From: [marianne leslie](#)
To: [Deb Estrada](#)
Cc: [marianne leslie](#)
Subject: SUB19-002
Date: Tuesday, January 23, 2024 9:00:33 PM

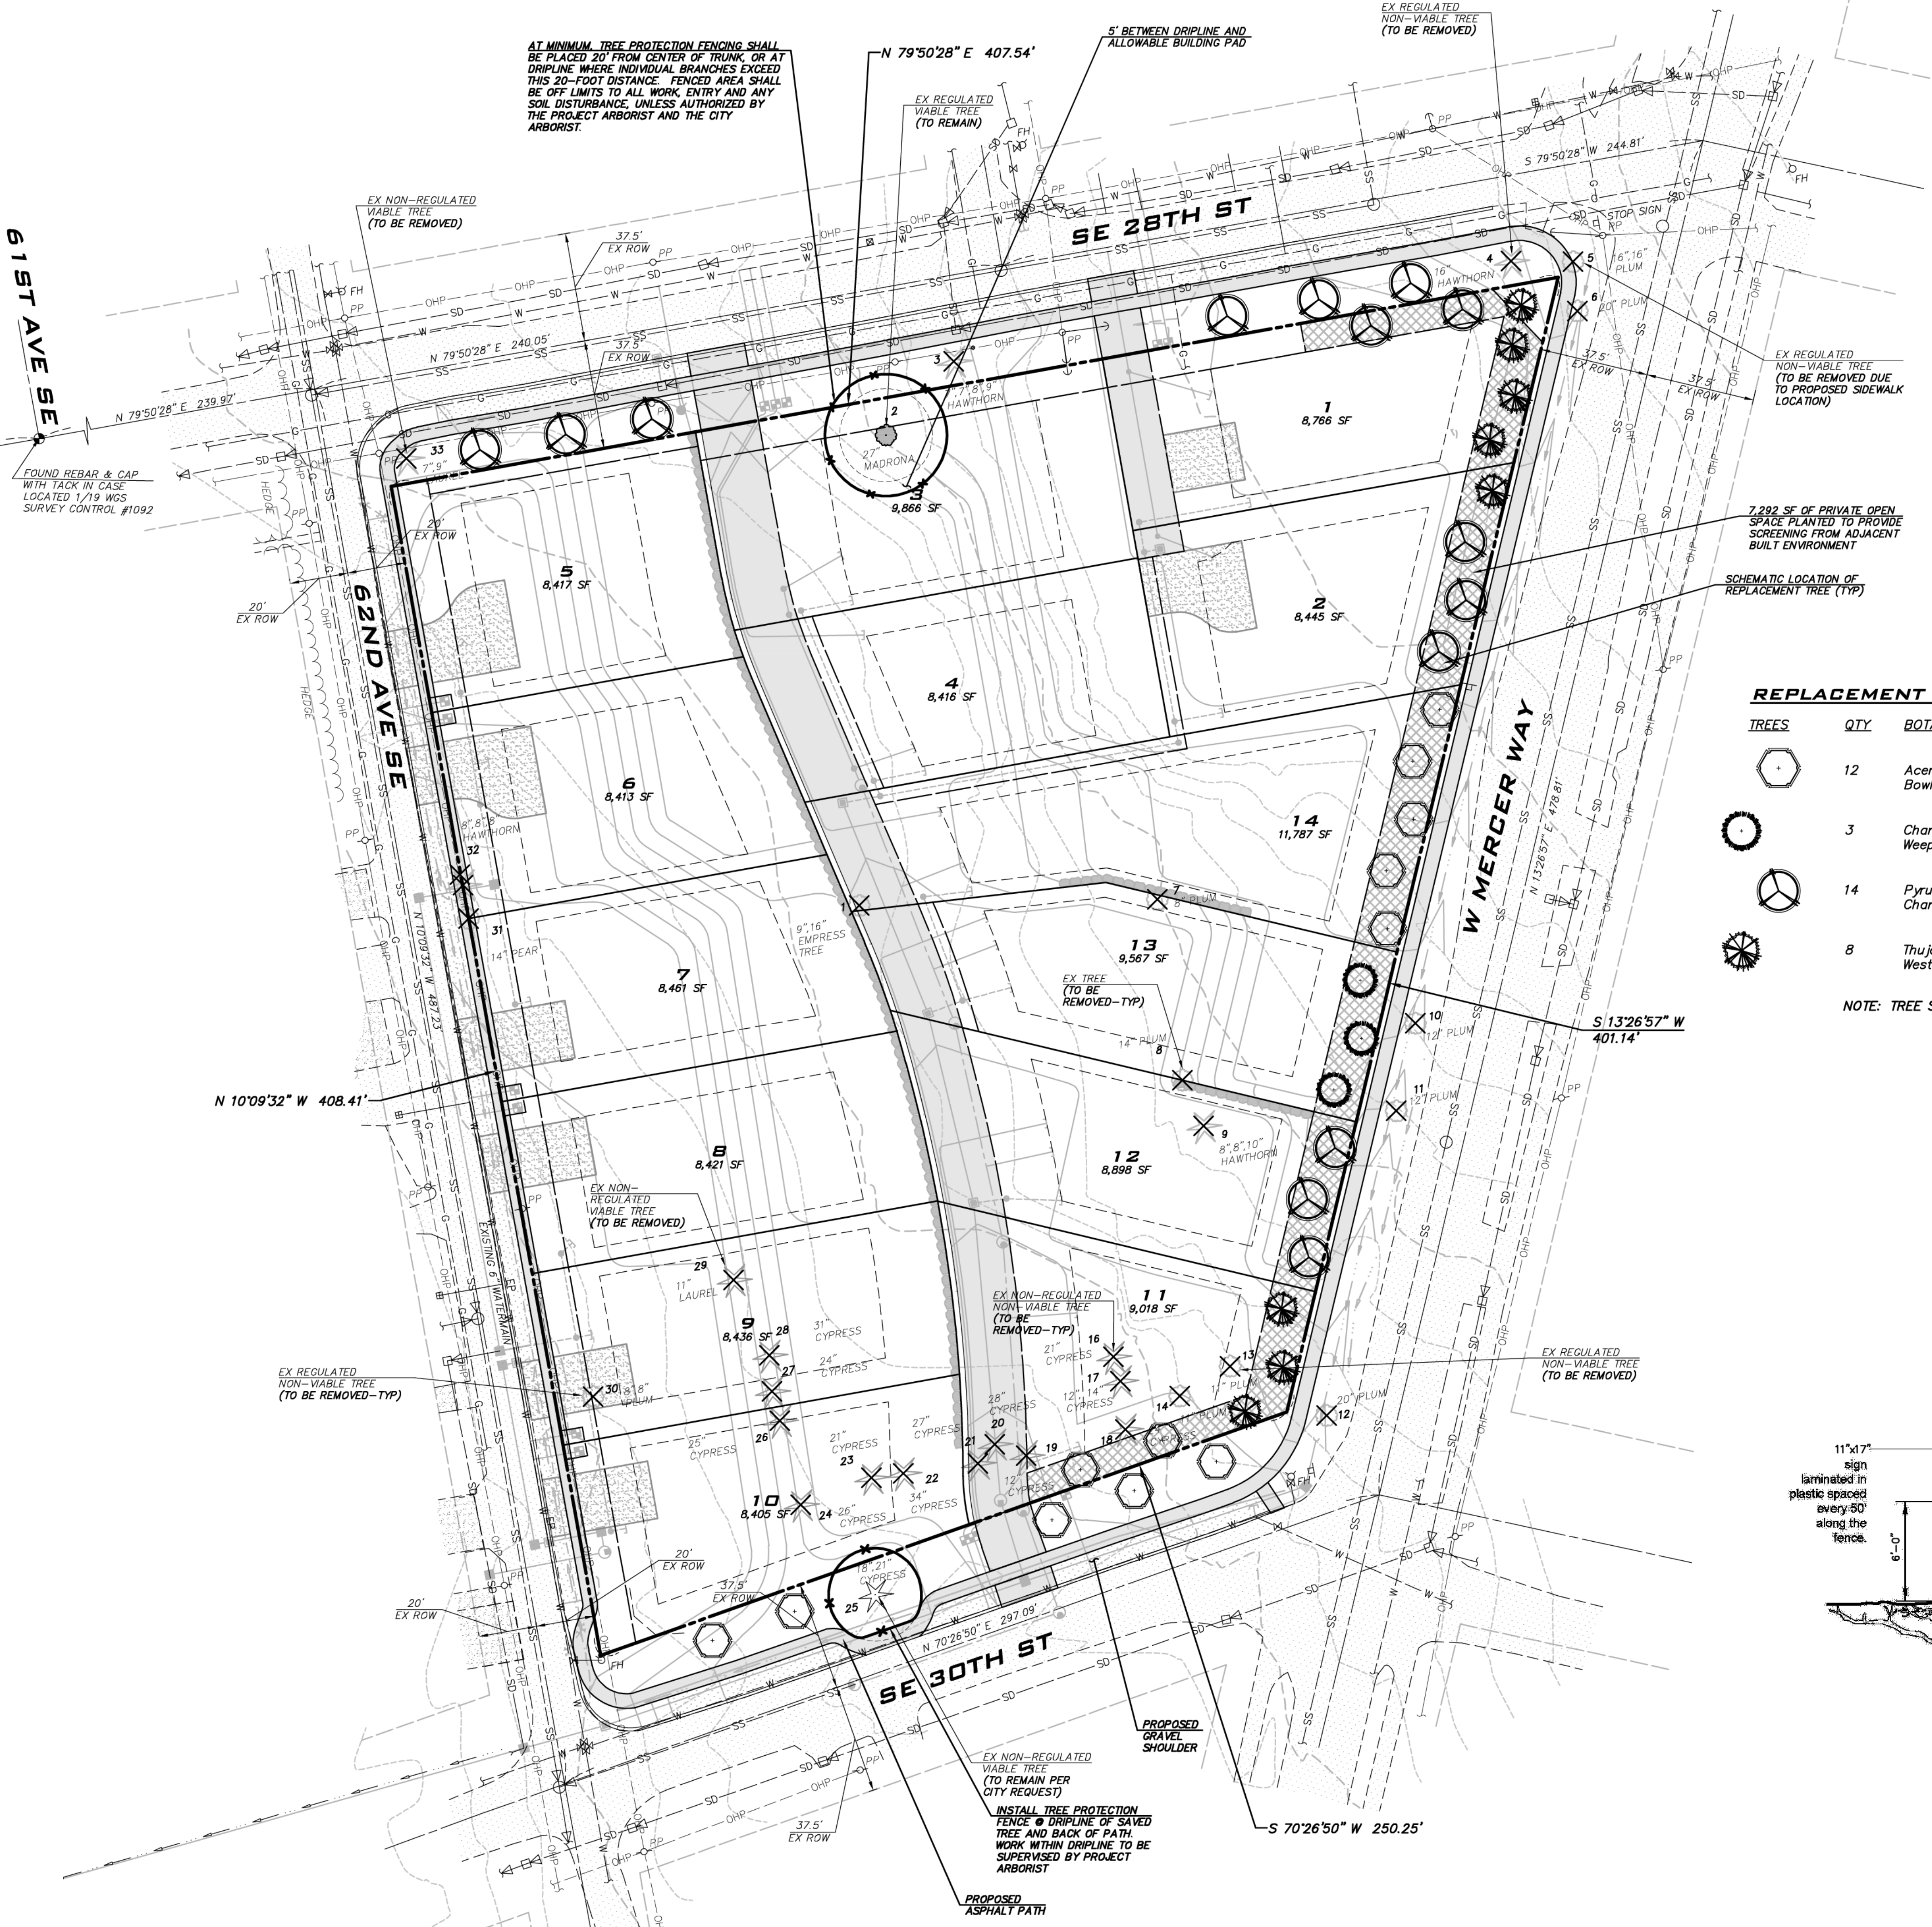
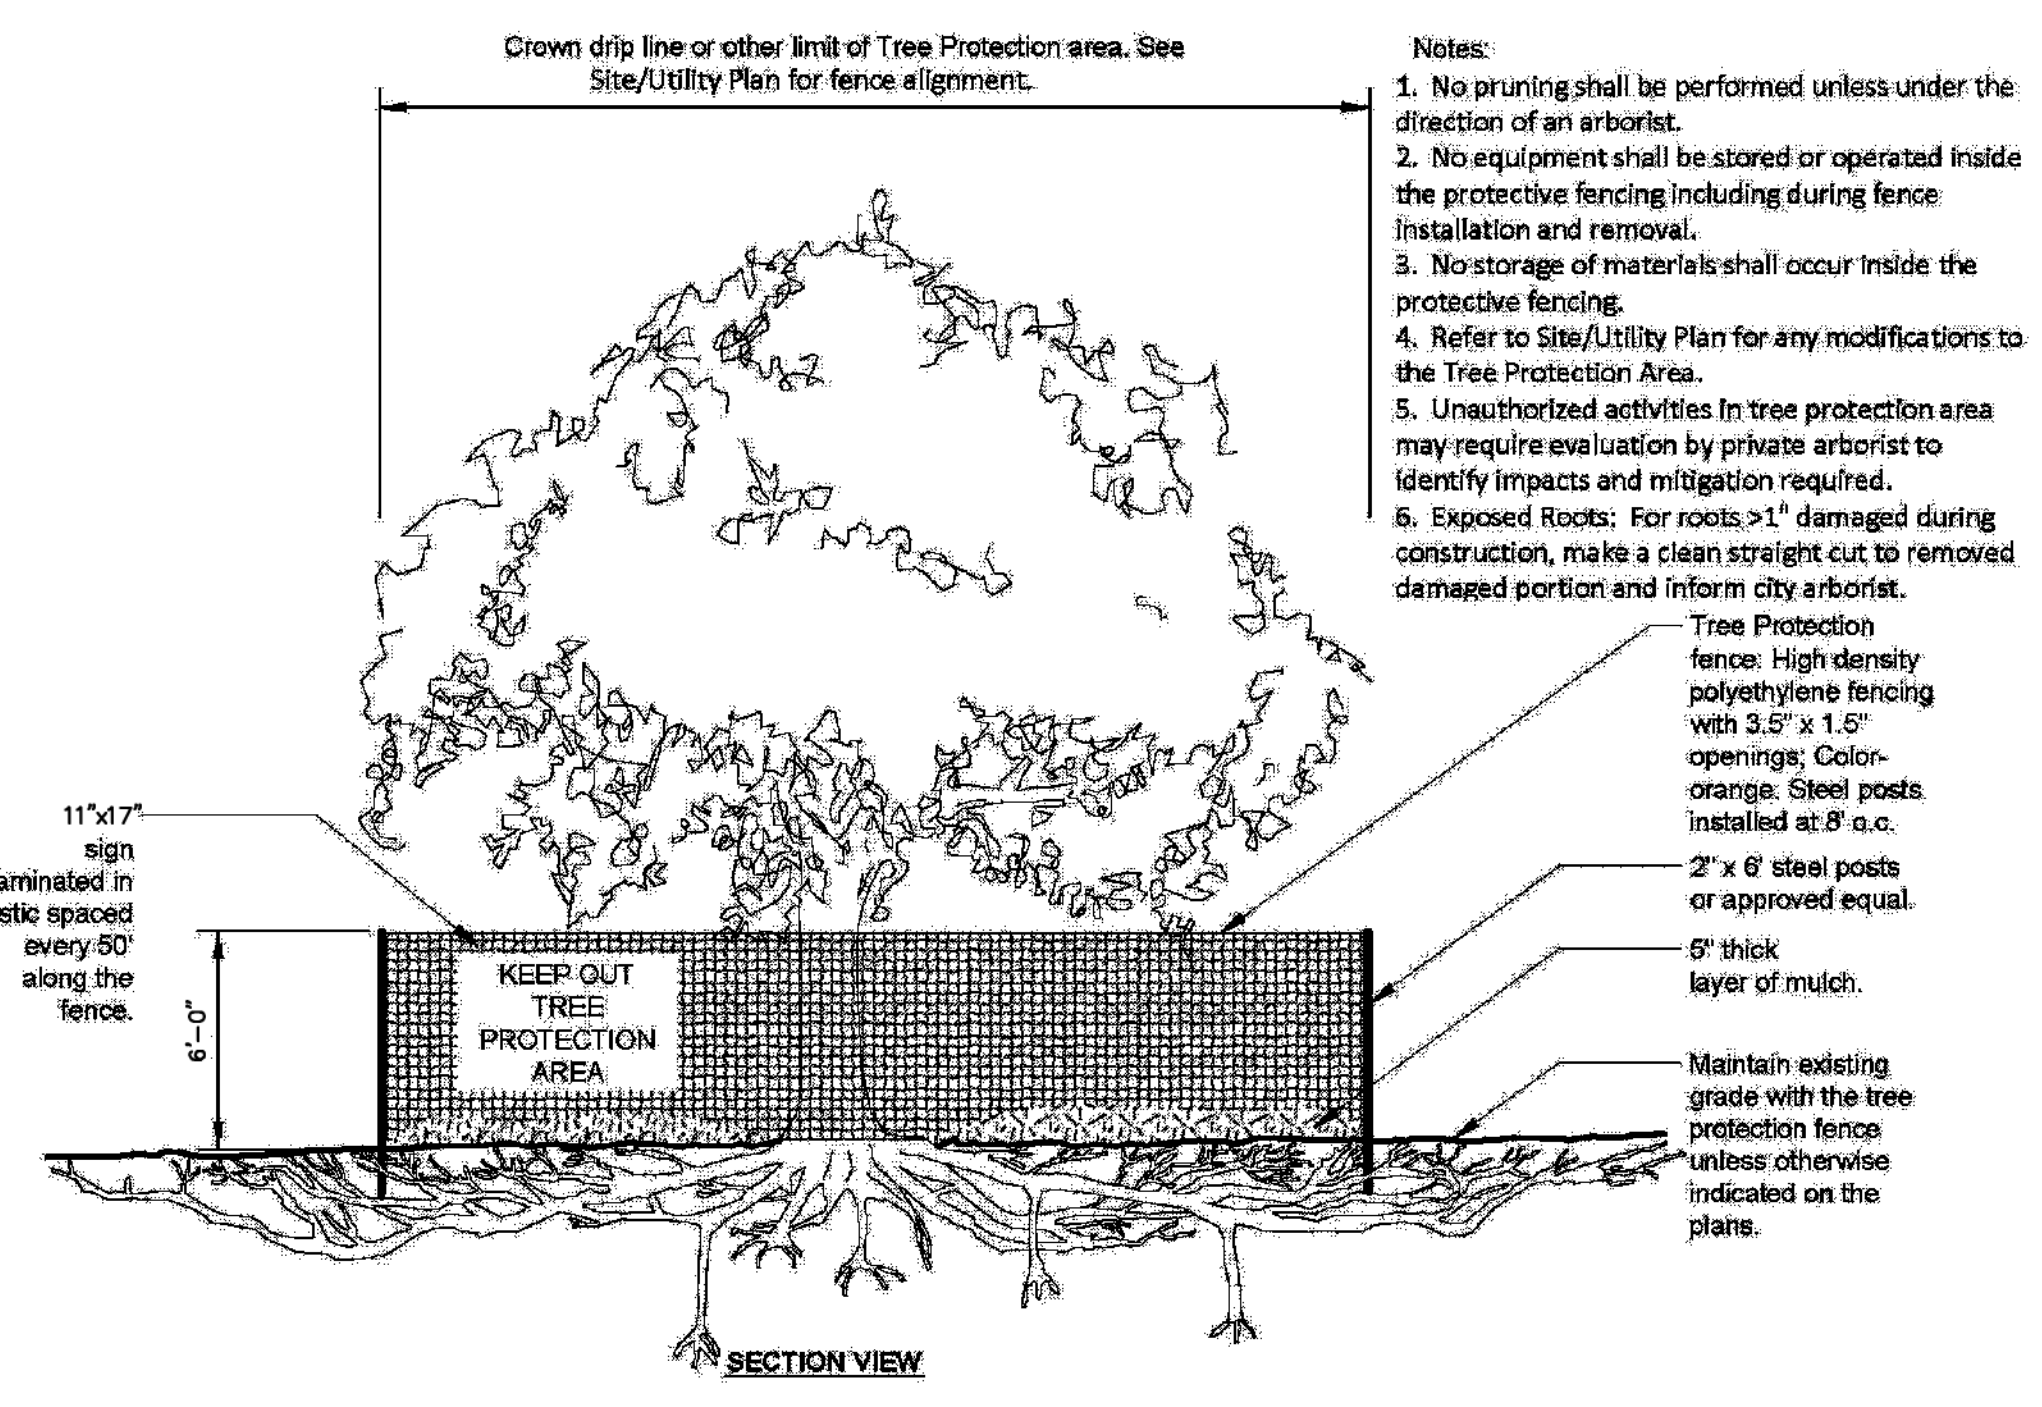
4. Current plan shows 26 new trees are required by City, yet the plan shows an additional 37 trees will be planted around the perimeter. What viable reason is there to cut down existing mature evergreen trees? The City of MI has strict rules that prevent removal of many trees. What would make the City now allow these mature trees to be cut down?

The replacement trees proposed to be planted along SE 28th and West Mercer will grow taller than the homes at maturity. Some will grow 45-50' tall, unlike the heights reported on the developers plans. The notation on page 9 of the BlueLine

plans read “*Space planted to provide screening from adjacent built environment*”. The developer identifies to screen new homes from existing homes, and shows no regard for the negative impact tall trees will have on the neighboring properties, “...*adjacent built environment*”. If you want a buffer, then plant trees that will only grow 20-25’. You don’t need trees like Red Cedars that will grow to 45-50’ just to provide a buffer to a 30’ tall house.

In Dec 2019 at the “in person” hearing regarding this development, I personally asked Eric Hansen to please use dwarf trees and plantings that would not grow taller than the new homes. He acknowledged that was a reasonable request. Somehow, that consideration was either overlooked or never considered at all. I will ask again for dwarf trees and no plantings in or around this community that will be taller than the homes at maturity. The mature tree heights listed on the plat plans are not all correct. The City should also support this so those neighboring properties with existing views do not lose those views over time. That would devalue those property values. By limiting plant and tree height, it will preserve and protect current views from many neighboring properties, and provide buffers and greenery for the new community.
